DOC17/599447-01
SSD 8647

SSD 8647 – HORNSBY HOSPITAL RE-DEVELOPMENT – ENVIRONMENTAL IMPACT STATEMENT (EIS)

- ENVIRONMENT PROTECTION AUTHORITY COMMENTS – HORNSBY HOSPITAL RE-DEVELOPMENT STAGE 2 EIS

Noise Monitor Along Burdett Street: Tuesday 06 June, 2017

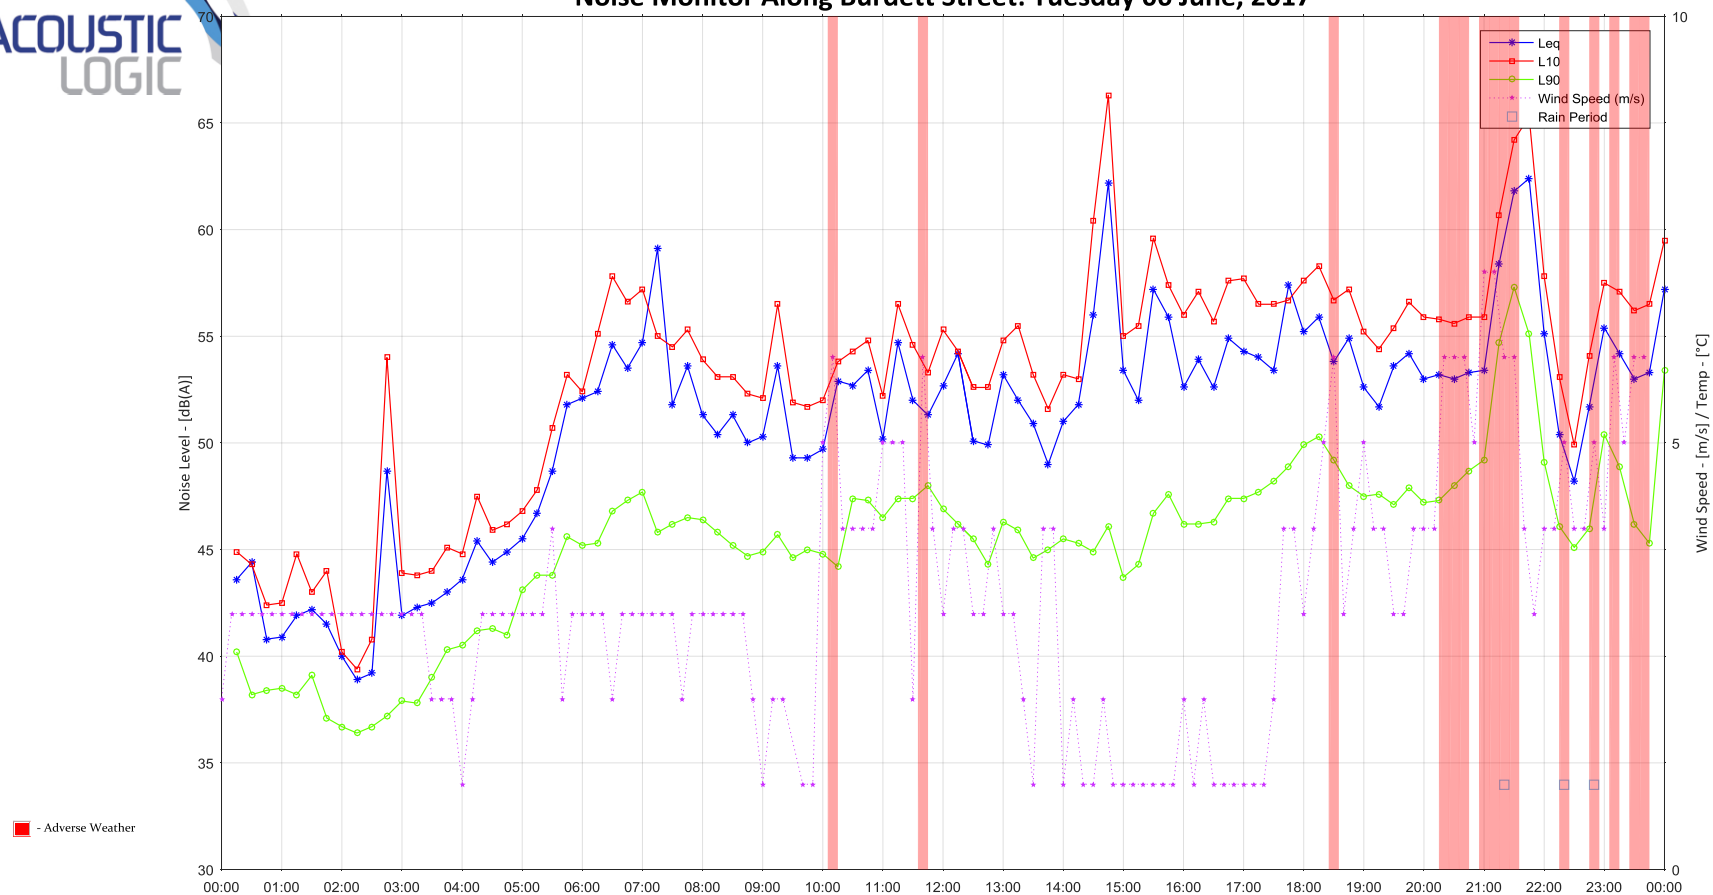
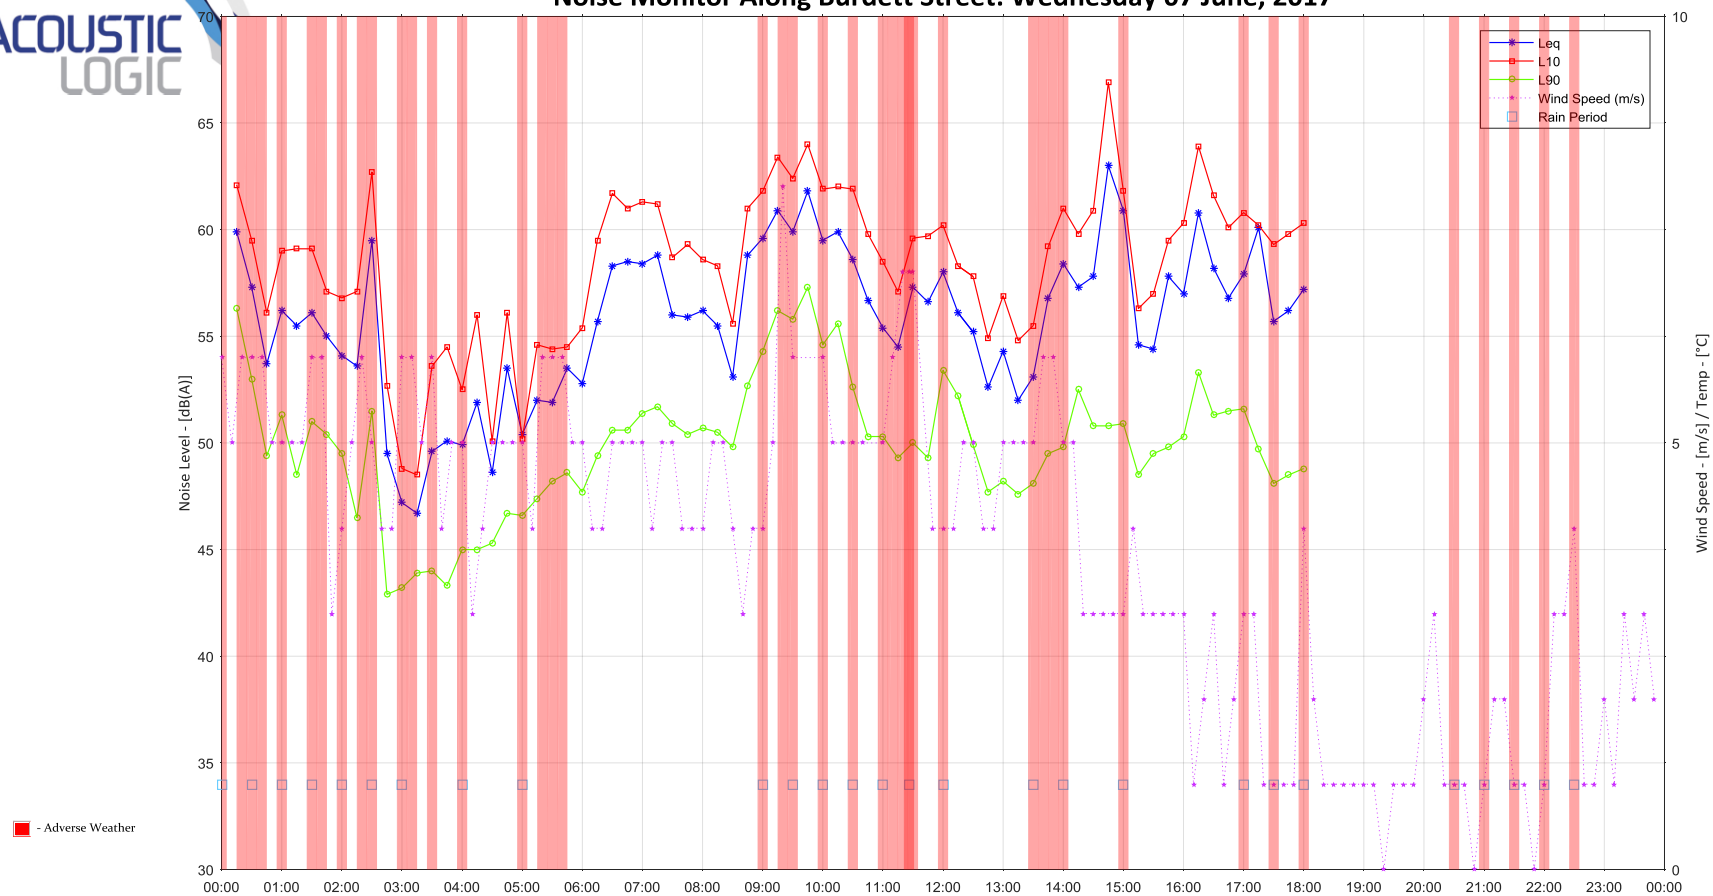
Section 4.1 to Appendix Q states that "[o]n review of the monitoring data, the measured L_{90} noise levels during high wind speed days generally do not increase background noise level significantly". The EPA considers the foregoing statement to be inaccurate for the graphs presented of the Burnett Street data, which show exactly the opposite for the evening of 6 June and all the data for 7 June.

The EPA is further concerned that in respect to the background noise monitoring graphs appended to EIS Appendix Q –

- (a) the legends to some monitoring graphs appear to be misaligned (e.g. wind speed, rain period),

- (b) the legends to monitoring graphs includes a blue marker for 'rain period' and although rain was observed on several days during the various monitoring periods (i.e. 24 May to 7 June 2017), no rain periods are represented in the graphs, and
- (c) some of the monitoring graphs include sections of red highlight, but there is no red marker in the legend to those graphs to identify the meaning of those red highlighted periods, and
- (d) Appendix Q does not appear to identify when noise monitoring loggers were last laboratory calibrated which brings into question reliability of the recorded data.

- (a) the equivalent of a week's worth of valid data, measured at the potentially most affected noise sensitive receiver locations in Burdett Street, Derby Street and Palmertson Road; and
- (b) the results of attended monitoring, graphical results of unattended monitoring with a complete and accurate legend together with a table of assessment background and daily ambient levels.
